**Project Name: \*** Widening of I-95 to Eight lanes from South of SR 1832 (Murphy Road – Exit 56) to South of SR 1811 (Bud Hawkins Road – Exit 70)

## I-5986A 4C Interagency Concurrence Point Meeting Minutes

An interagency concurrence point meeting was held in order to reach agreement on concurrence point 4C for the I-5986A I-95 widening project in Cumberland County. The following items were discussed and conclusions reached:

PROJECT REFERENCE NO. <b>I-5986A</b>		SHEET NO. <b>8</b>	
RW SHEET NO.			
ROADWAY DESIGN ENGINEER		HYDRAULICS ENGINEER	
<b>INCOMPLETE PLANS</b> DO NOT USE FOR R/W ACQUISITION			
<b>DOCUMENT NOT CONSIDERED FINAL</b> UNLESS ALL SIGNATURES COMPLETED

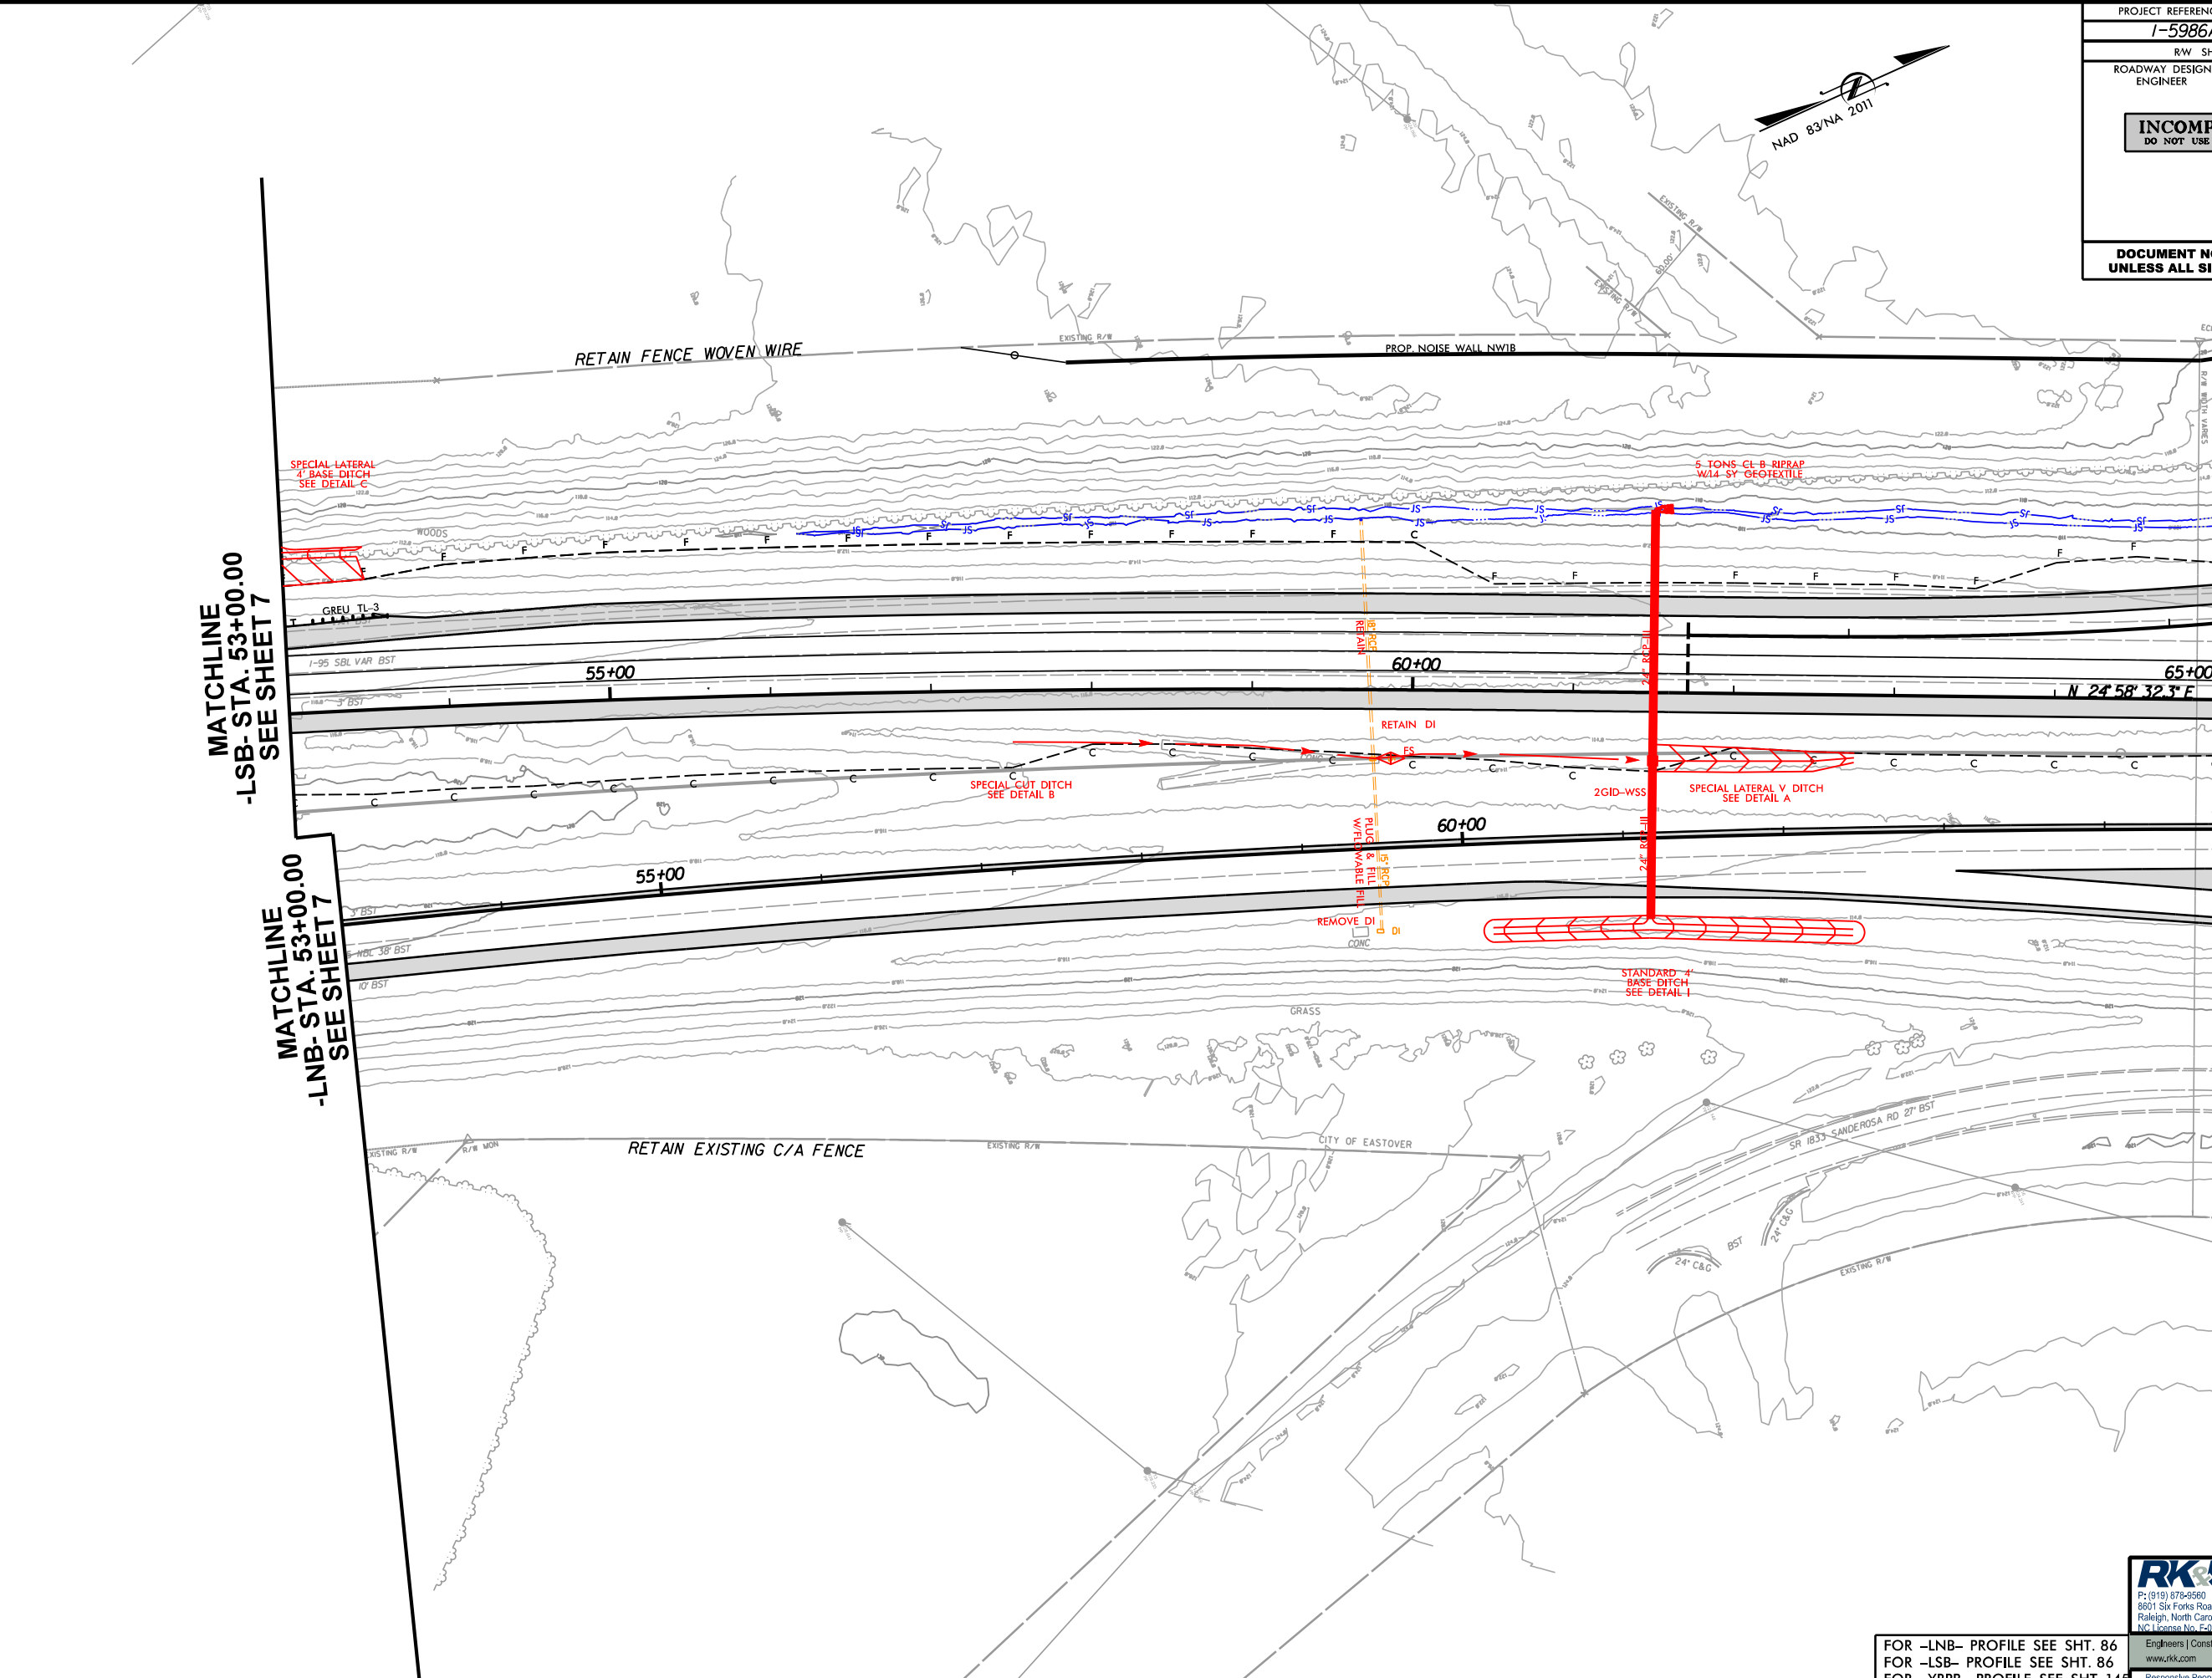
- **Site 1:** Stream DC. Impacts due to proposed pipe outfall.

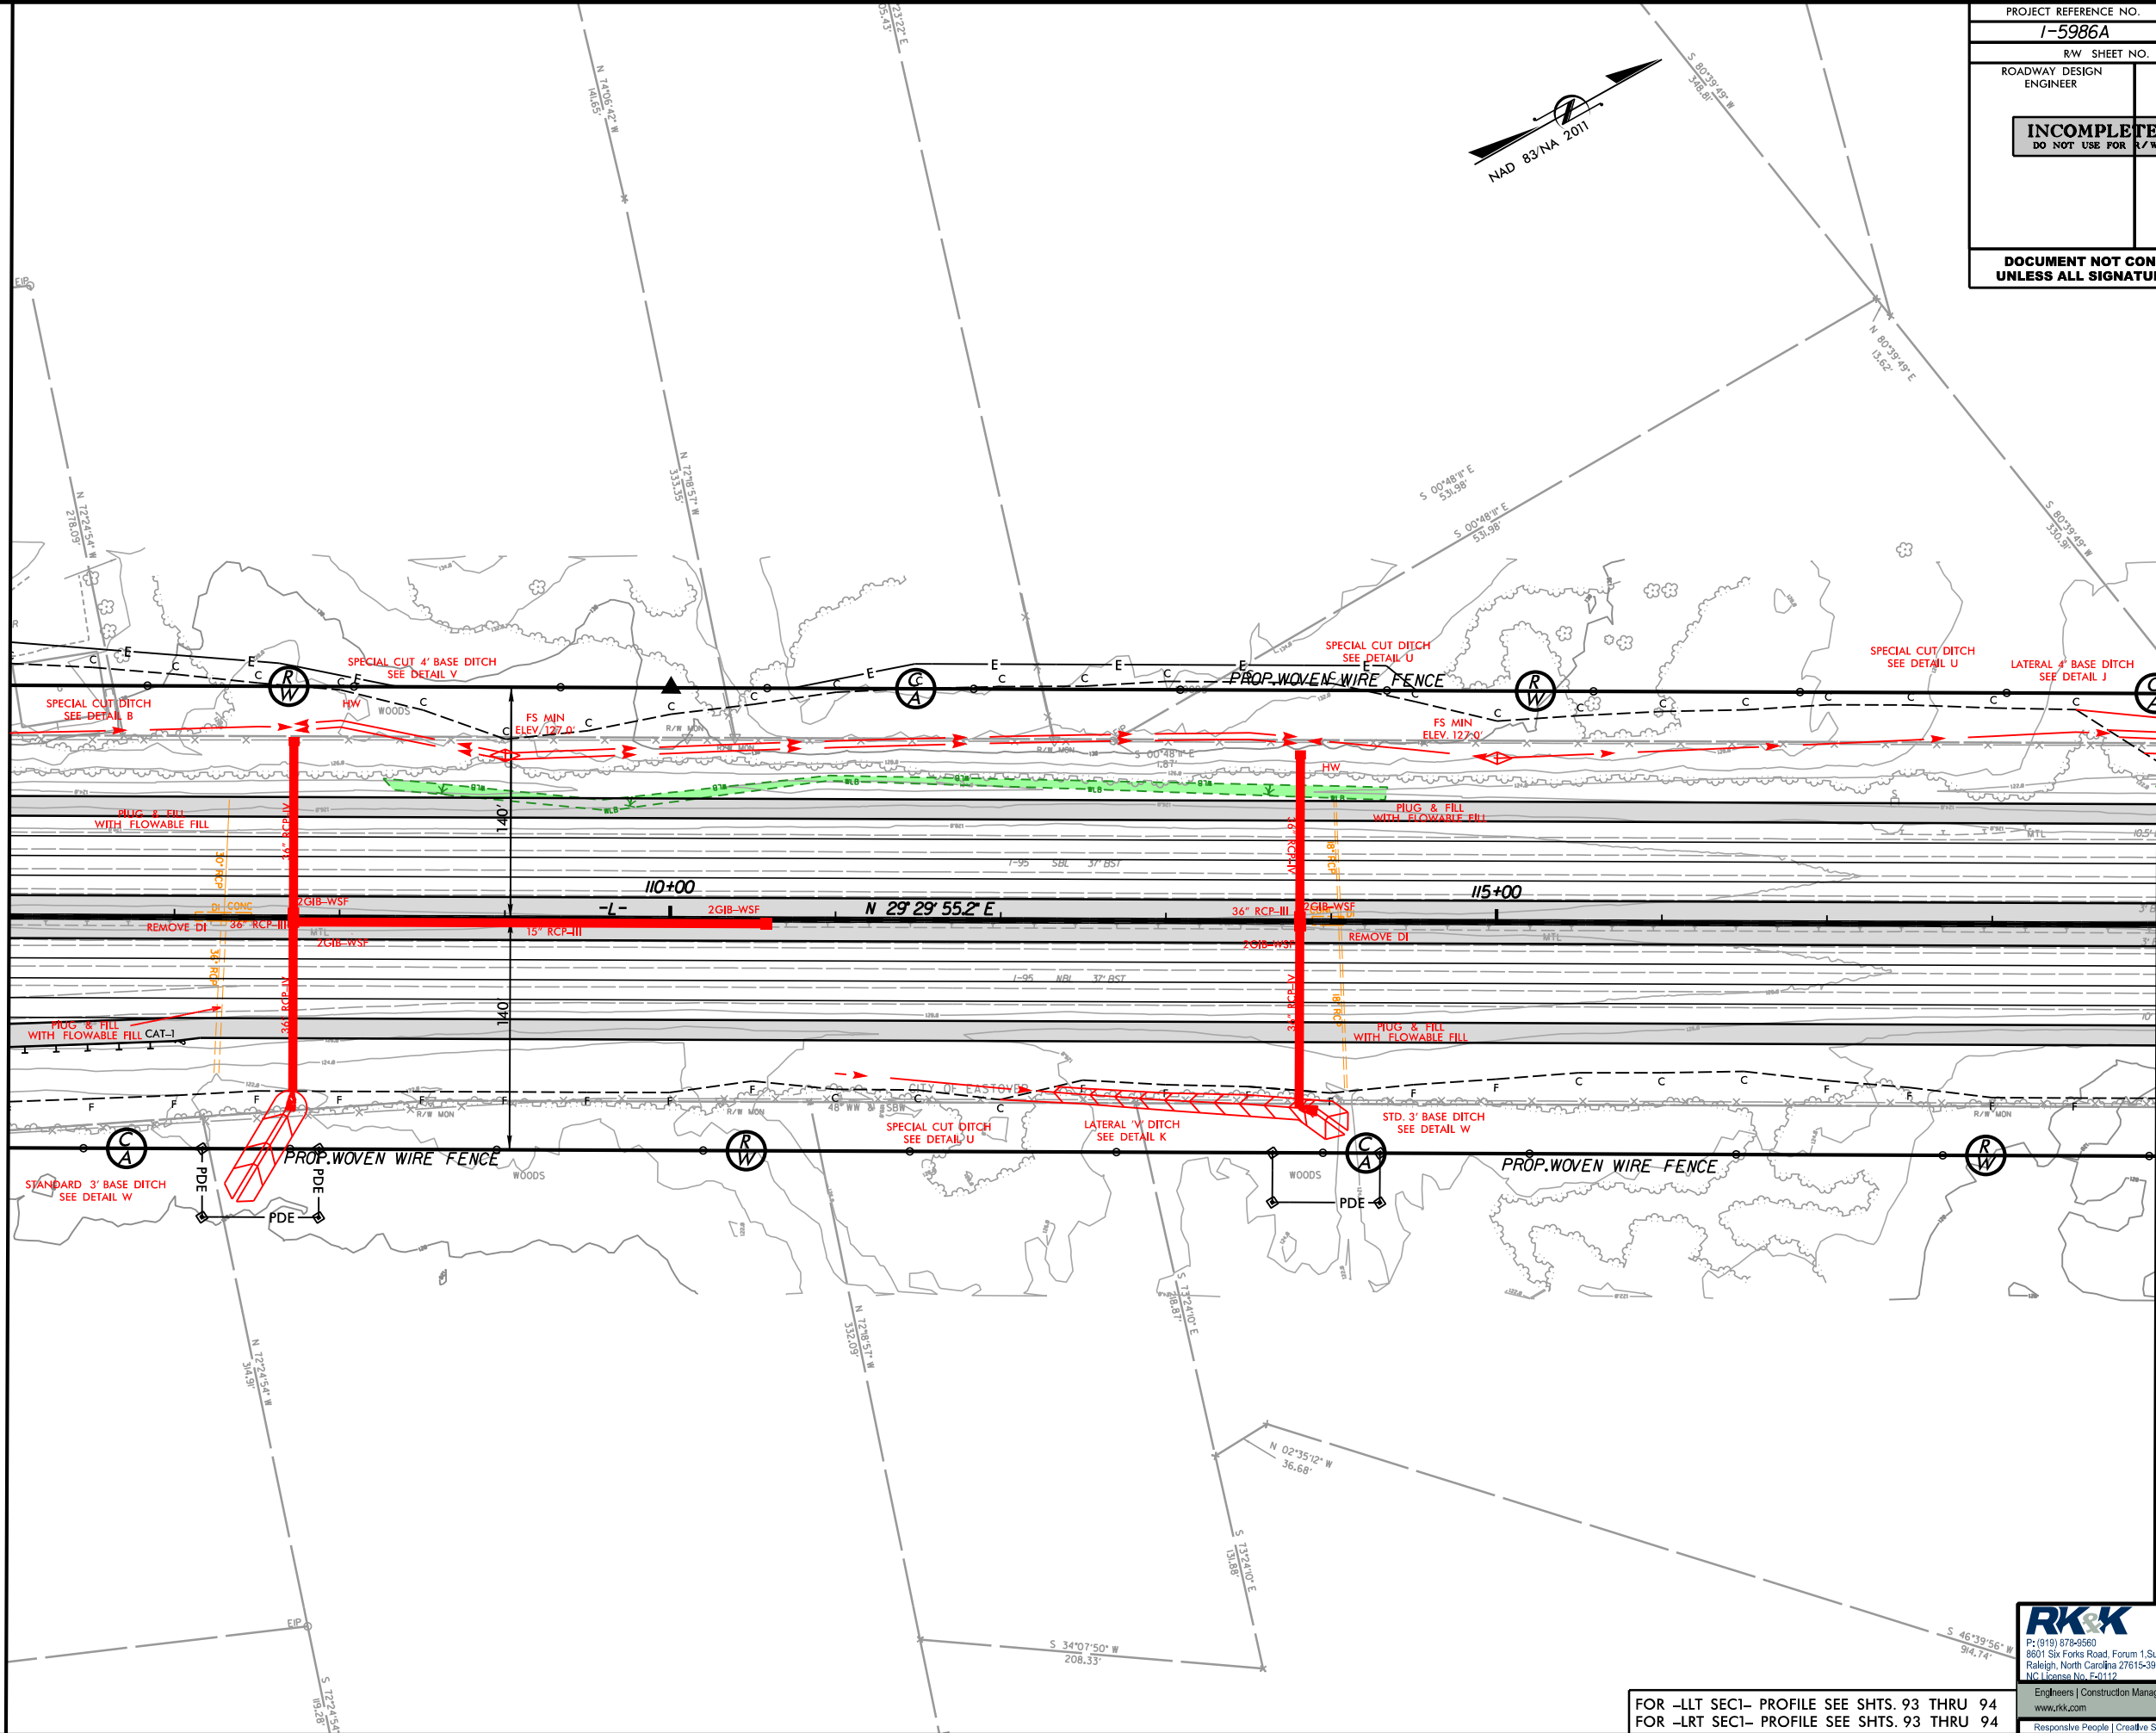
- **Site 2:** Stream SV-1, SV-2; wetland WCB. Impacts due to proposed 66" WS pipe (inlet end) and 66" RCP (outlet end). The existing RCBC will be retained, and the new pipe will be used as an overflow pipe (not buried). Impacts at the ends of welded steel pipes installed by bore and jack methods throughout the project (as this one will be) used a standard 50' x 30' bore pit area to determine impacts. This area was used on both the bore end and receiving end. This is because the contractor is unsure at this time which end will be the best for the boring end. Jim Rerko asked that the temporarily impacted bore pit locations be restored to natural conditions when construction is complete.
- **Site 3:** Reese Creek-1; wetland WA. Impacts due to existing pipe cleanout. See additional notes for permit drawing 16.

PROJECT REFERENCE NO. <b>1-5986A</b>		SHEET NO. <b>26</b>	
RW SHEET NO.			
ROADWAY DESIGN ENGINEER		HYDRAULICS ENGINEER	
<b>INCOMPLETE PLANS</b> DO NOT USE FOR R/W ACQUISITION			
<b>DOCUMENT NOT CONSIDERED FINAL</b> UNLESS ALL SIGNATURES COMPLETED

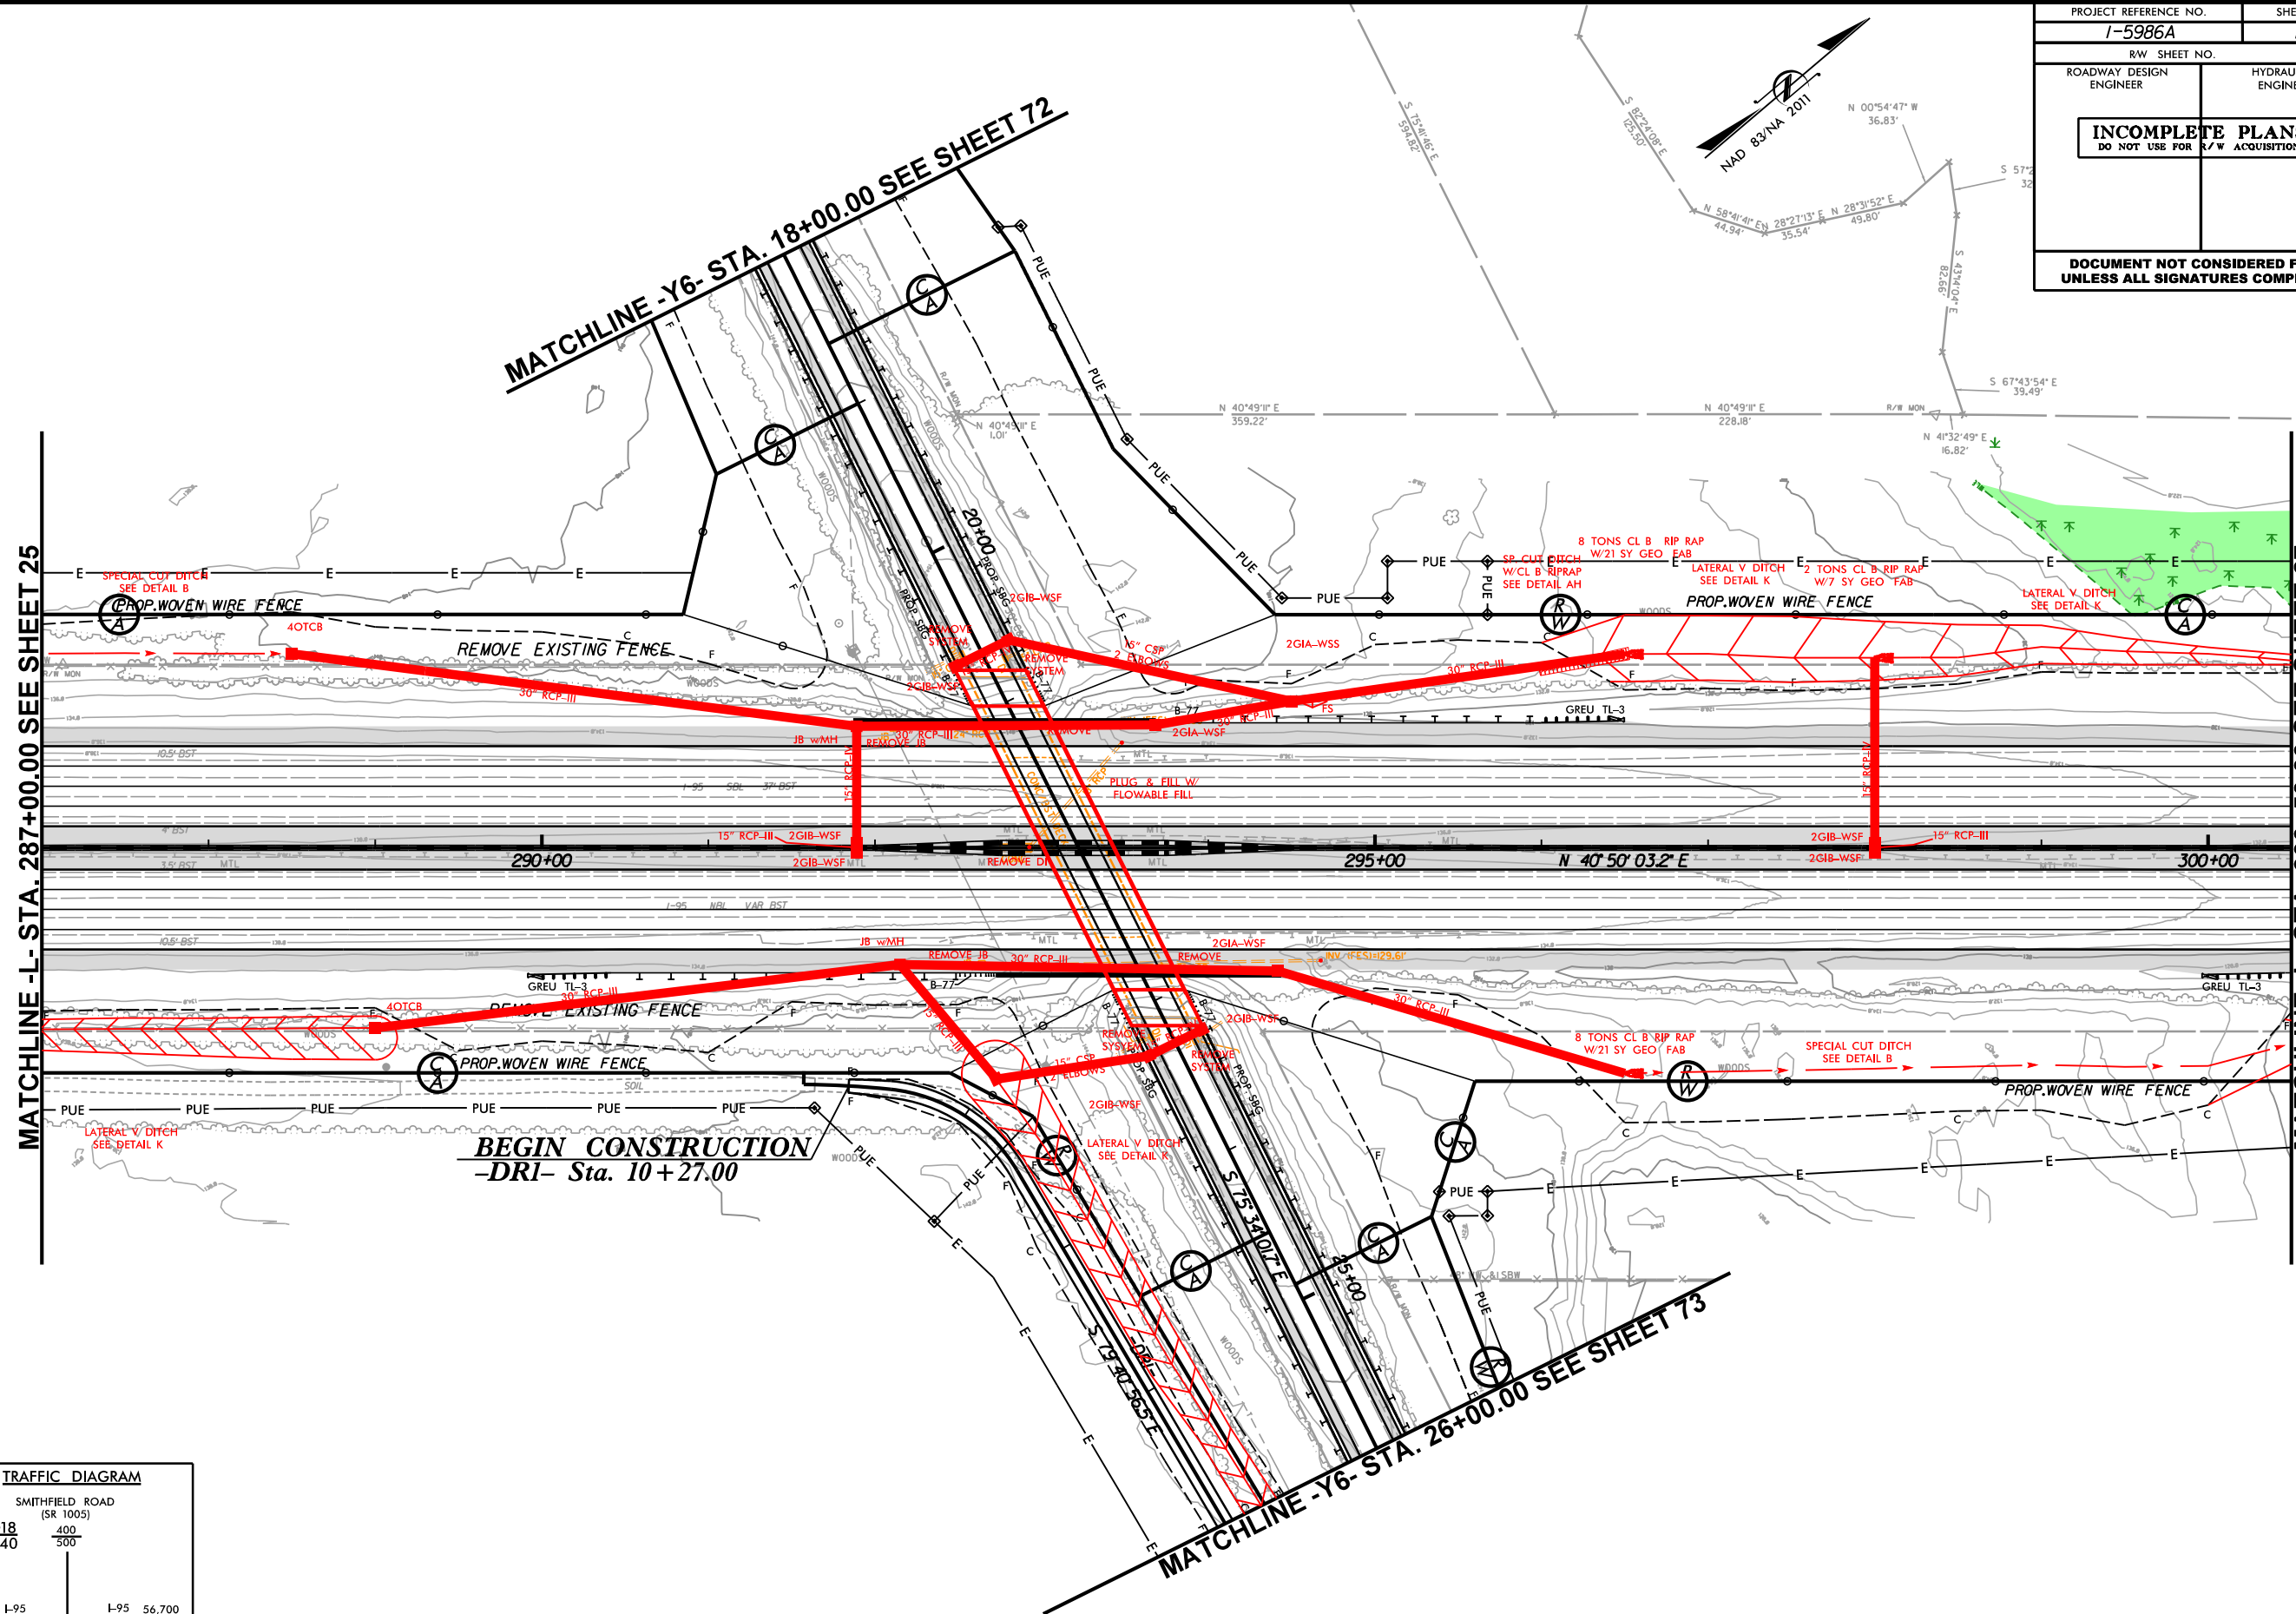
- **Site 10:** Wetland WI. Impacts due to proposed roadway fill. This will be a total take.
